Application No: EP/14/21/HH
Site Address: 38 The Roystons East Preston BN16 2TS
Description of works: Single storey side and rear extensions and conversion of roofspace to habitable use

Thank you for your internet representation made on 2nd March 2021 which has been recorded as an objection with the comments as follows:

The committee agreed to raise the following objections to this Application.

Drawing
Proposed first floor plan

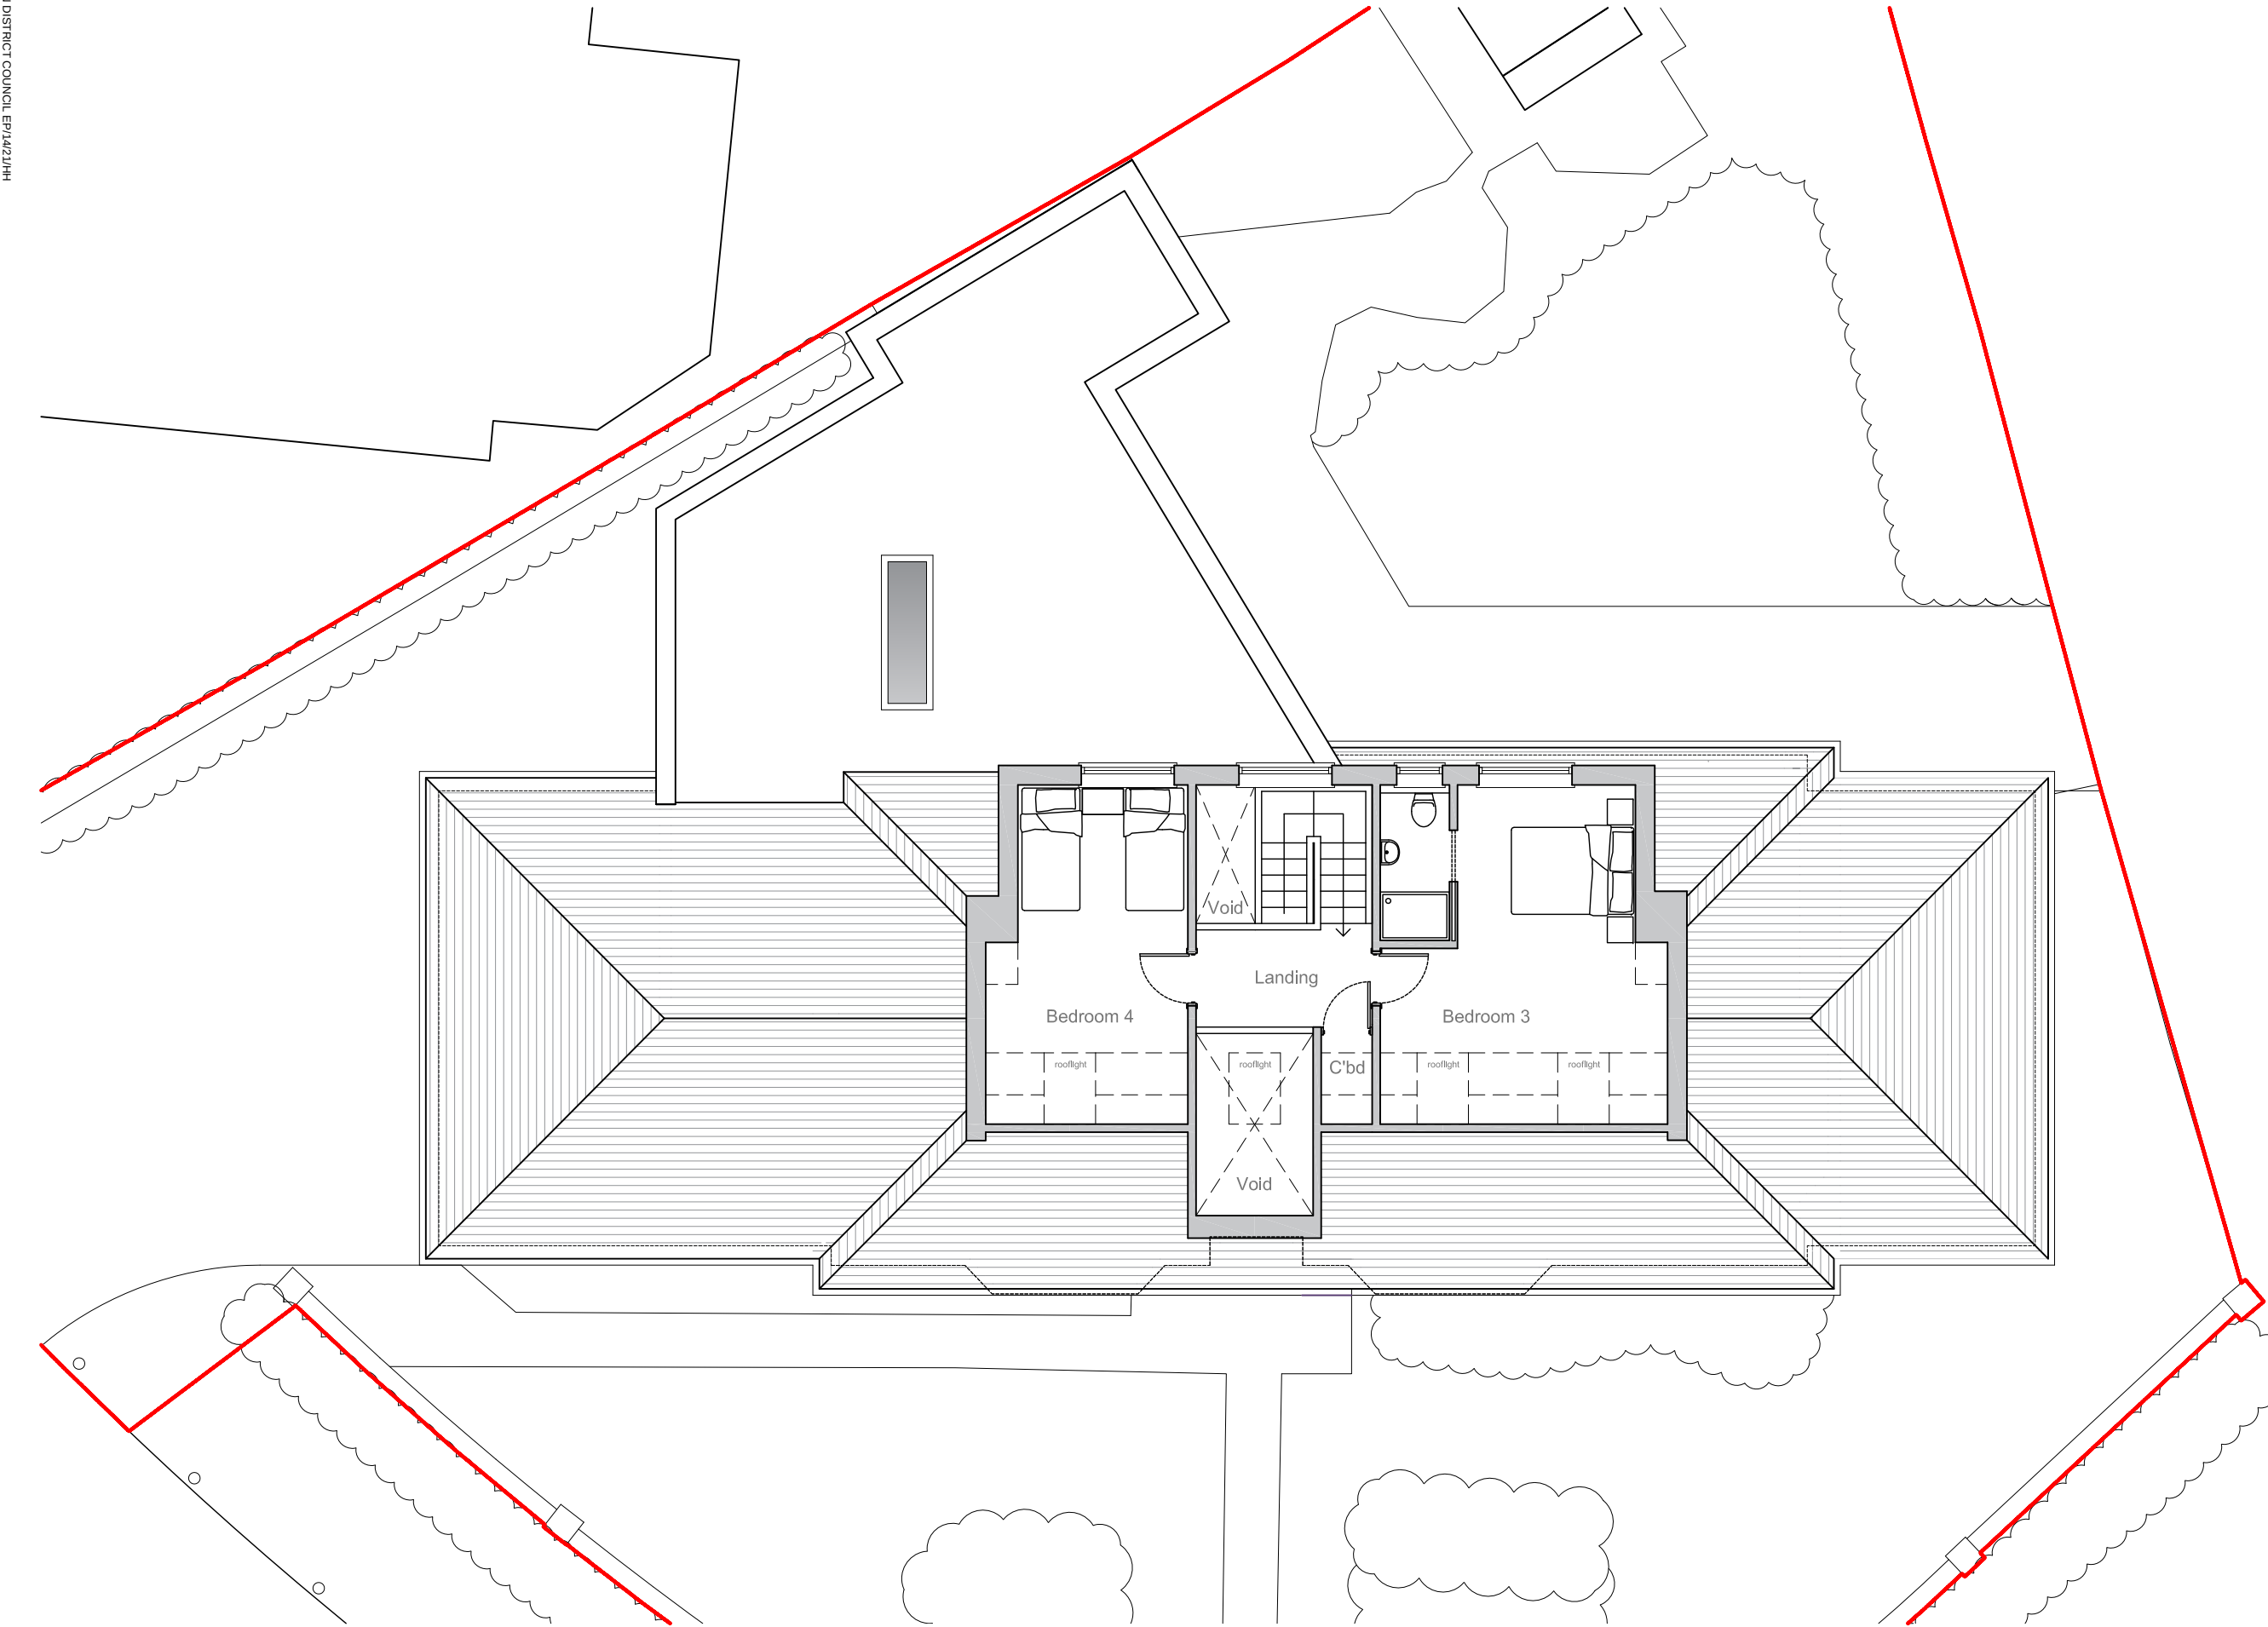
As neighbours have already commented, the proposed building will reduce the privacy of the back gardens of several neighbouring properties. This would be unneighbourly.

Drawing
Proposed elevations

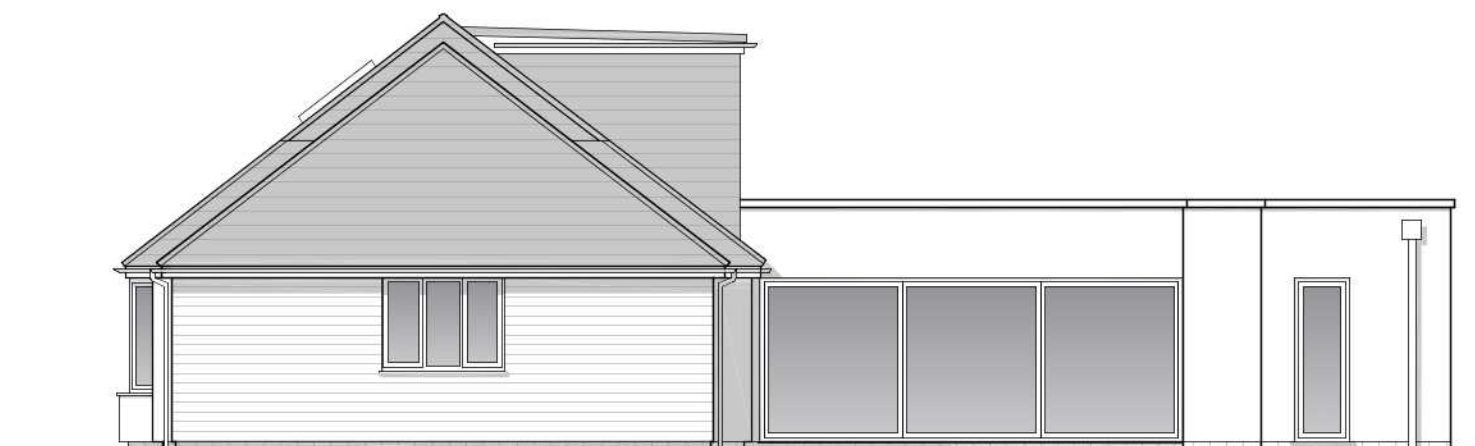
The proposed materials do not harmonise in both colour and texture with the materials used in adjoining buildings thus conflicting with Policy 1 of the East Preston Neighbourhood Plan.

The character of the existing building will be lost, features such as the eyebrow window and leaded lights placing the current property firmly in its time and location.
